**From:** Amanda Scholes on behalf of Planning.Responses  
**Sent:** 04 December 2014 16:49  
**To:** Planning Scanning; Amanda Scholes  
**Subject:** FW: Planning Consultation on: R/238/14/PL  
**Attachments:** Drainage - Supplementary Guidance Notes.pdf

**From:** Thomas Callaway  
**Sent:** 04 December 2014 16:27  
**To:** Planning.Responses  
**Subject:** RE: Planning Consultation on: R/238/14/PL

**PROPOSED SITE PLAN.
FEBRUARY 2013
1:500 @ A3.
4112-03^A**

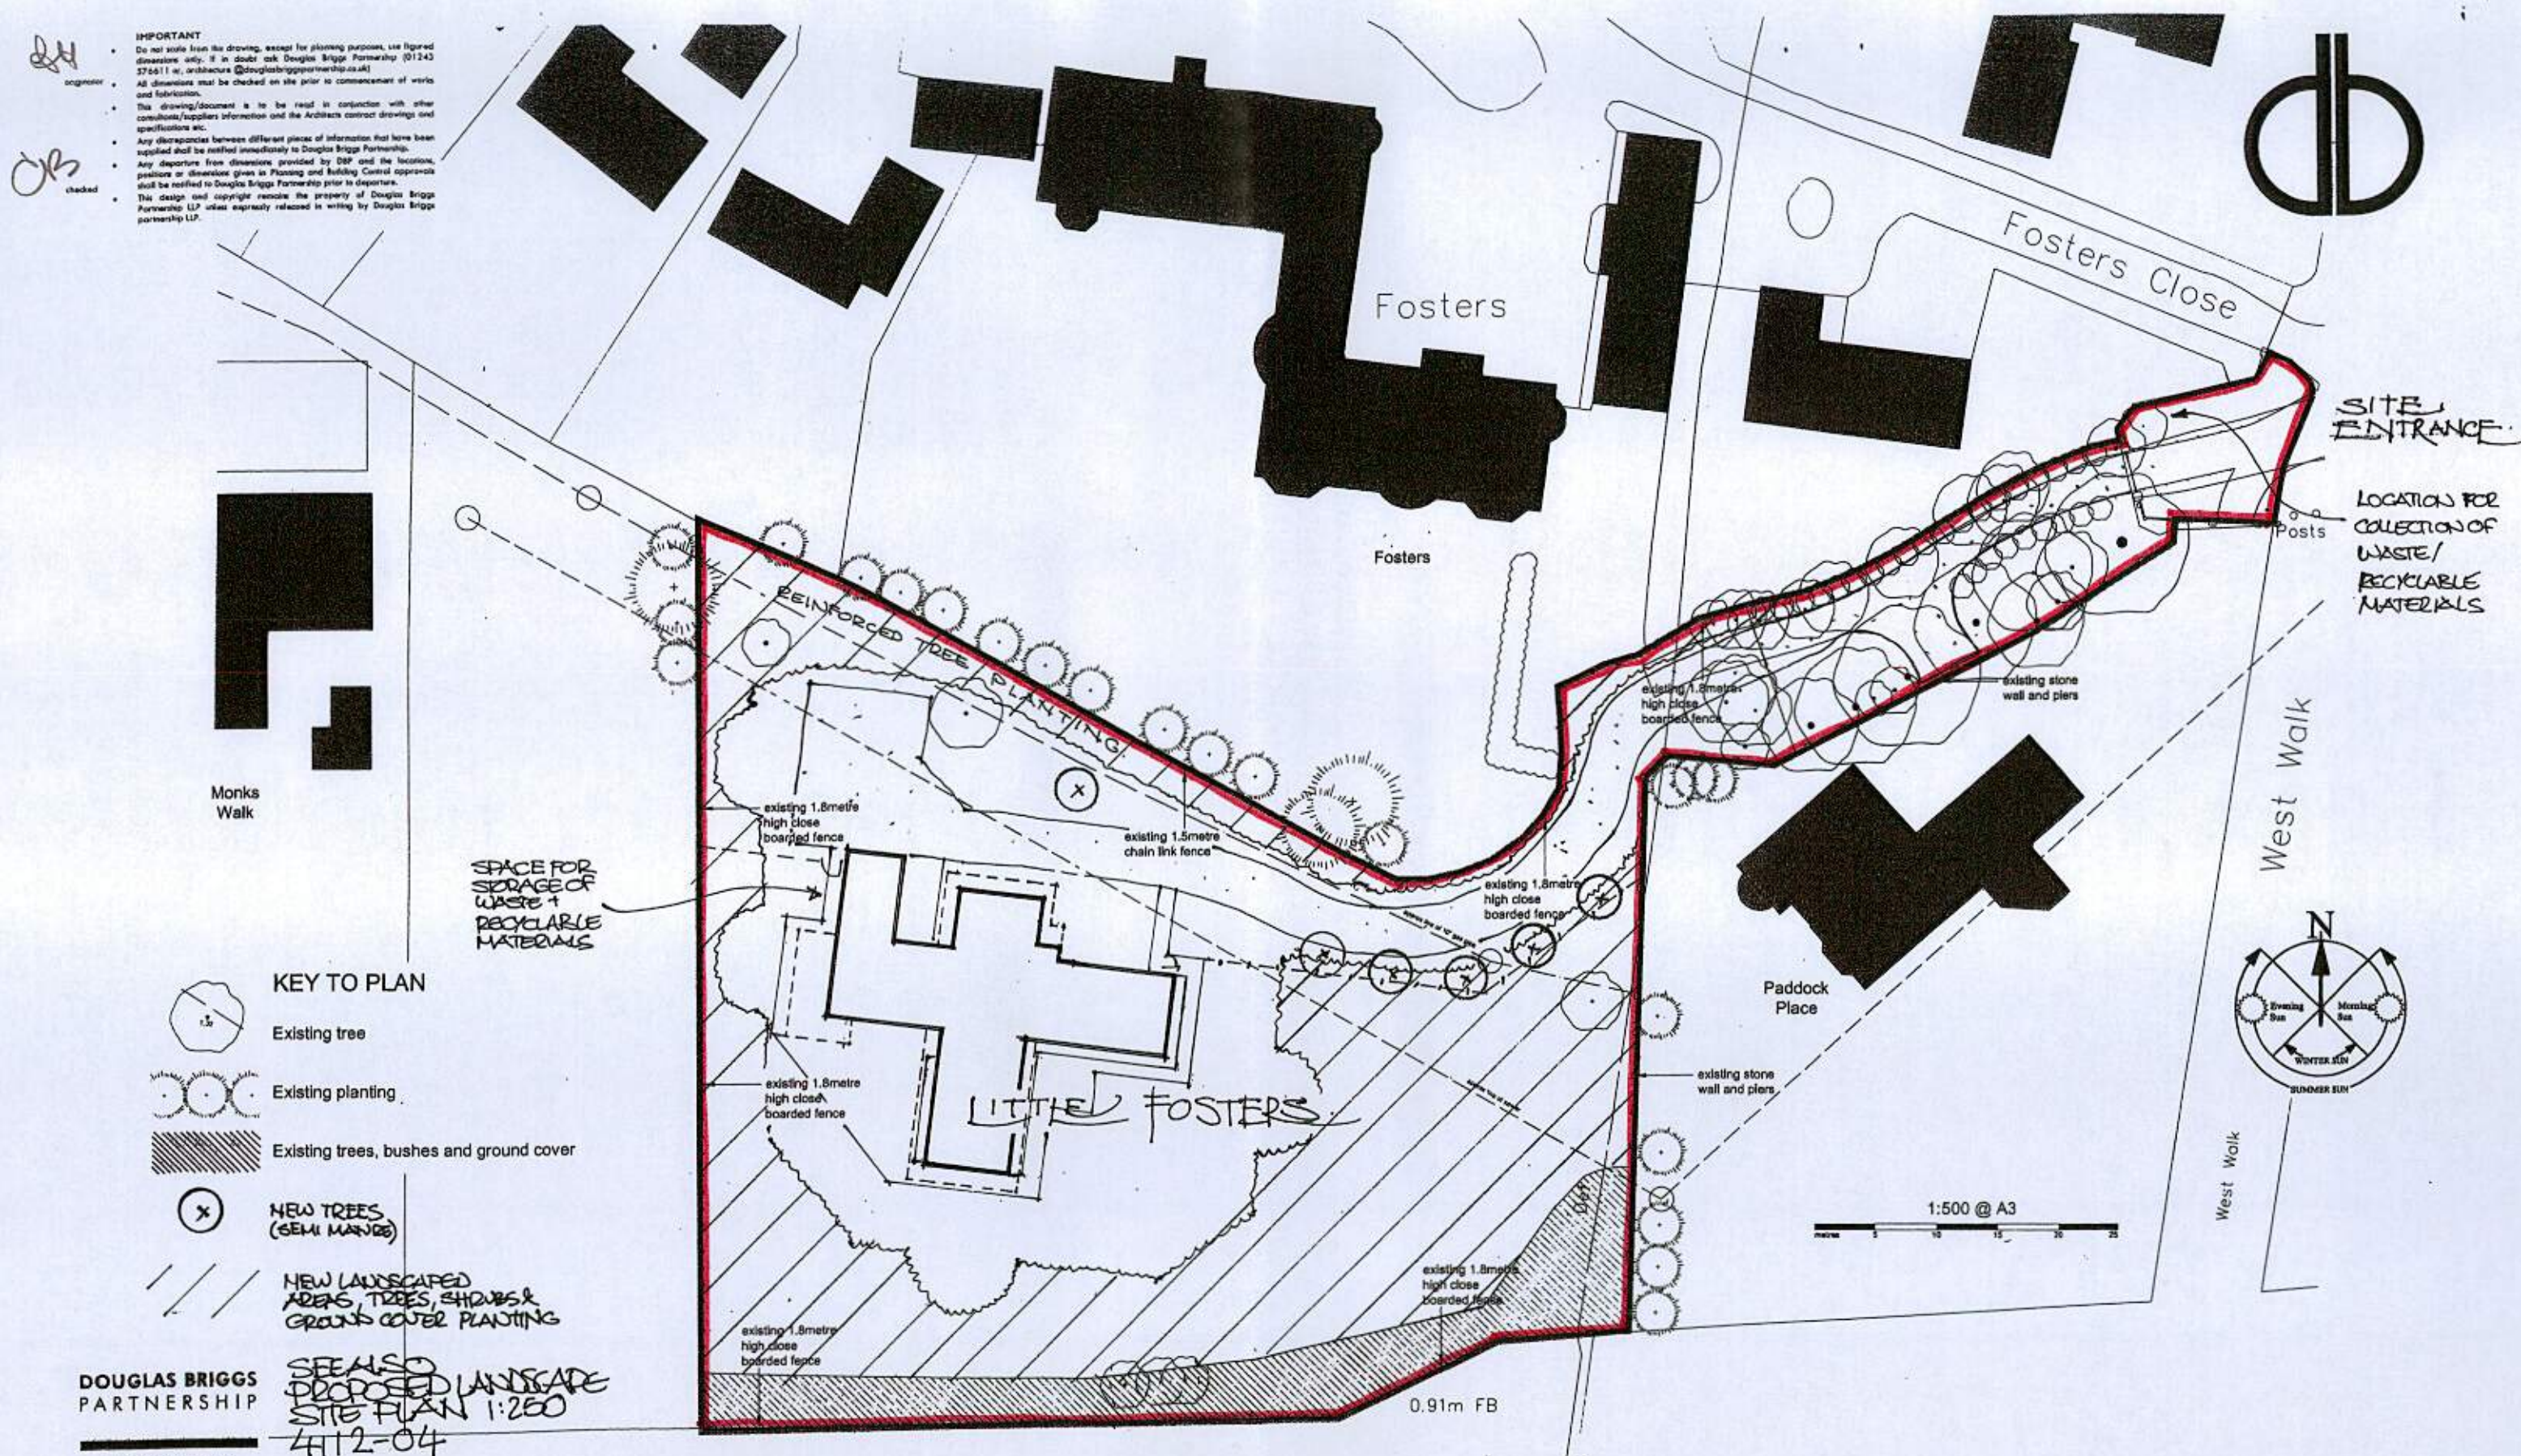
A culverted watercourse is likely to run along the line of the ditch within the property. This must be investigated to determine its exact location and purpose. It may be useful for the applicant to contact us regarding investigating the culvert and ditch.
